03/09/2020

Luddenham Resource Recovery Facility (SSD-10446)  
**Response to Submissions**

## ATTACHMENT 1

Figure 4.1 Water management system layout

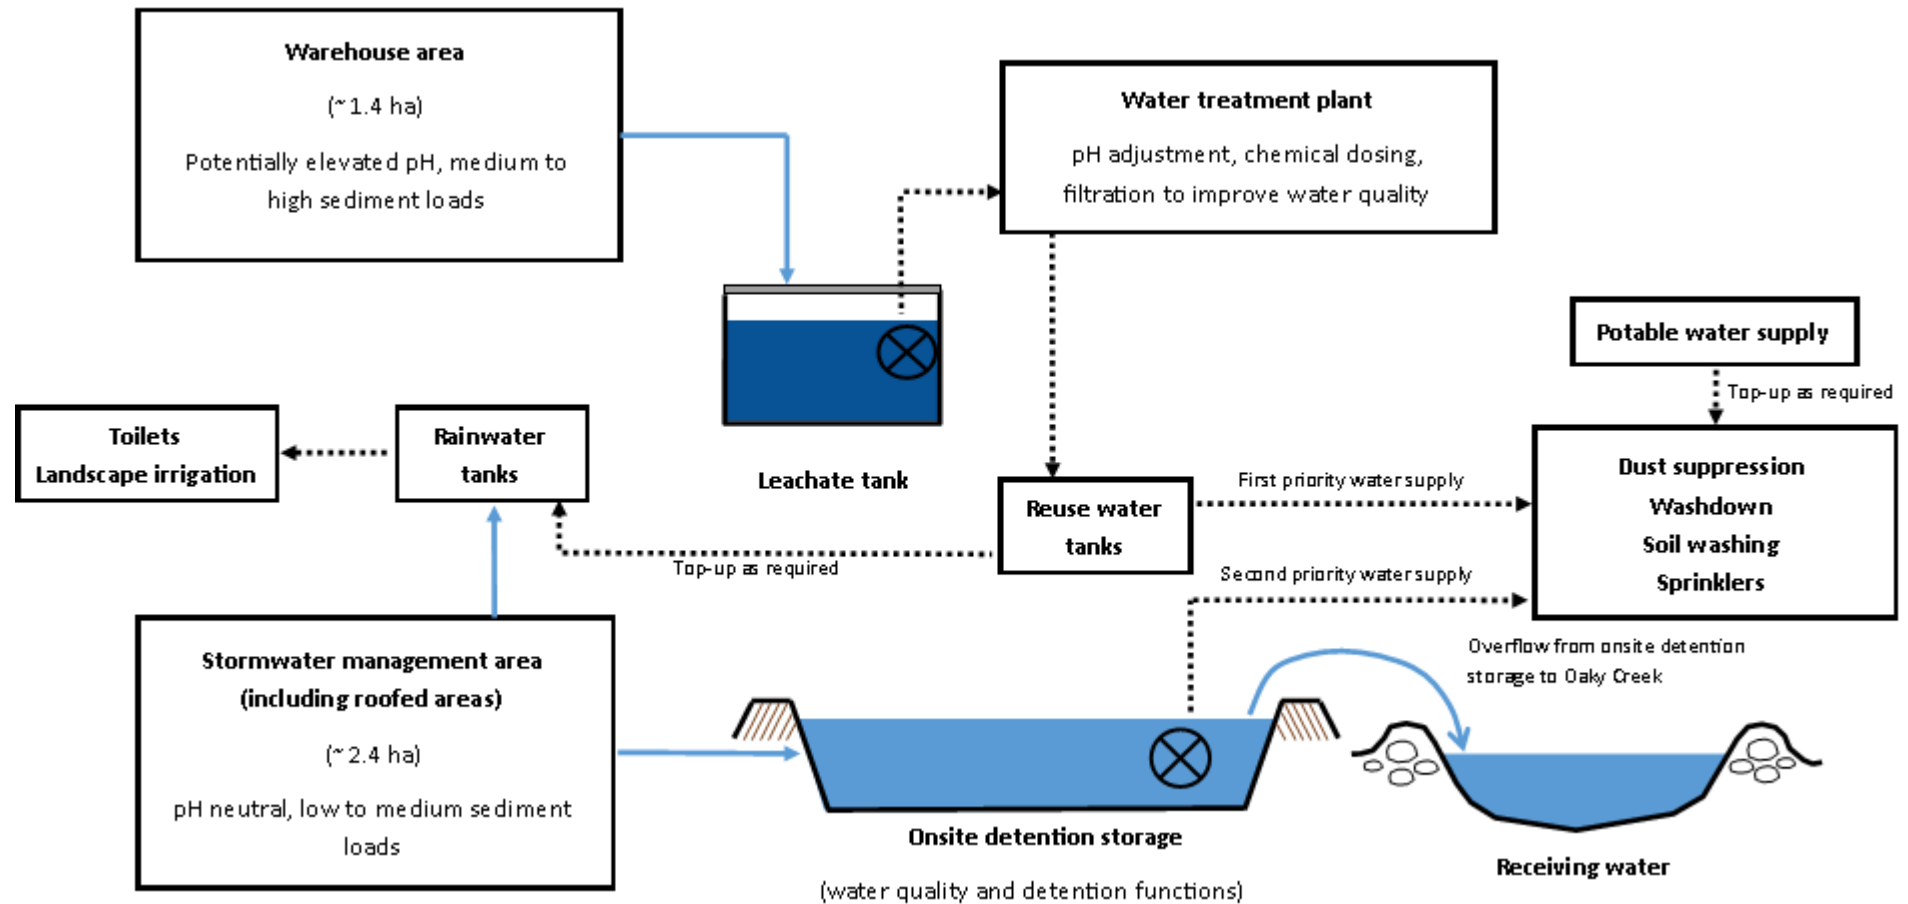
- It is noted a leachate tank is proposed to be located within the RRF for the capture of dirty water from processing operations. Please update the site plans to show the location of the internal leachate collection system. Furthermore, please provide details on the following:

- It is understood stormwater overflows from the proposed onsite detention storage basin will discharge to Oaky Creek. Provide details on how water quality will be assessed and monitored from the overflow of the stormwater detention basin. Please update site plans to show the location of the stormwater discharge point into Oaky Creek.

Figure 6.1 Contribution to exceedances for cumulative 24-hour PM₁₀ concentration at R3

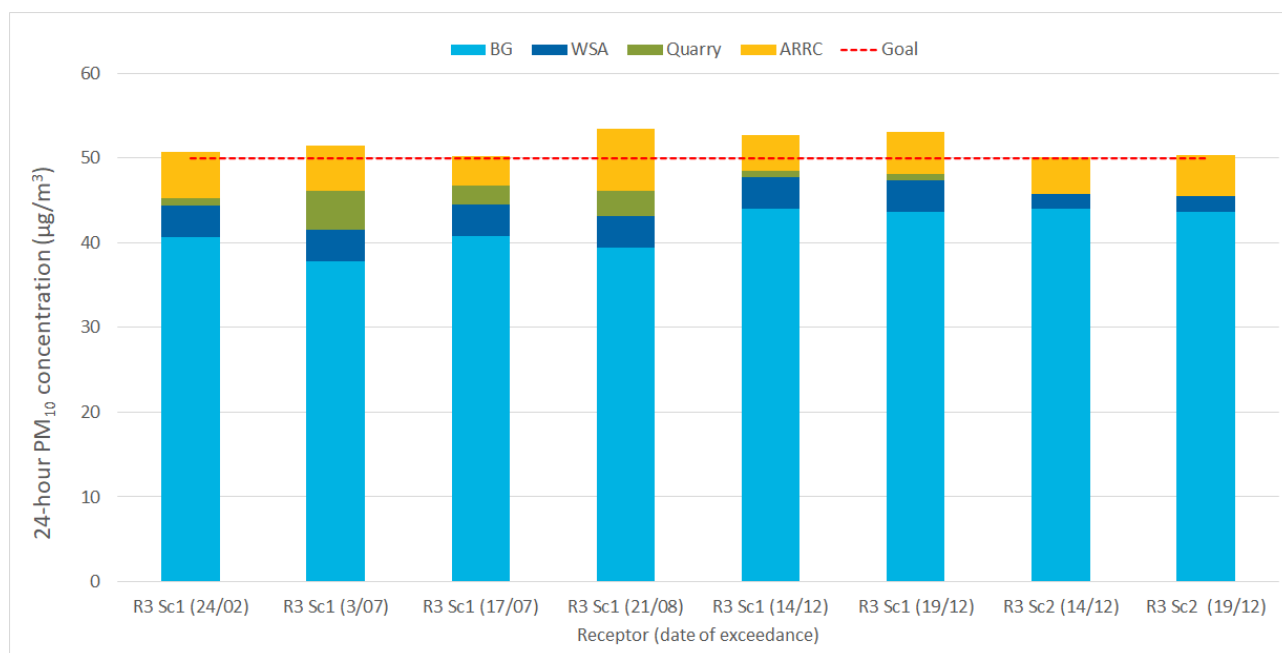
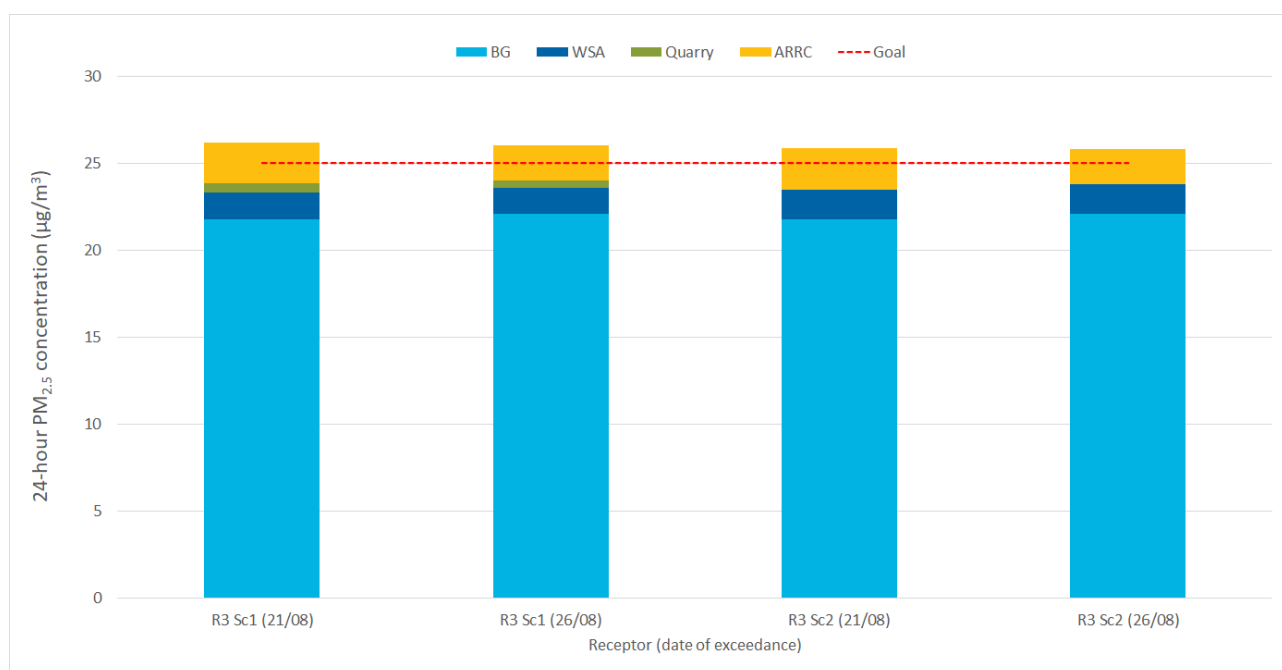
- The Air Quality Impact Assessment (AQIA) modelling results reported exceedances for 24-hour average PM<sub>10</sub>, annual, 24-hour average PM<sub>2.5</sub>, and annual average TSP at the nearby sensitive receptors, R3 and R6 associated with the cumulative scenarios, including Scenario 1 (concurrent operation of the RRF with the quarry, and construction of the Airport) and Scenario 2 (concurrent operation of the RRF with the operation of the Airport following the rehabilitation of the quarry). Provide details on the air quality mitigation measures proposed for exceedances identified at sensitive receptors R3 and R6.
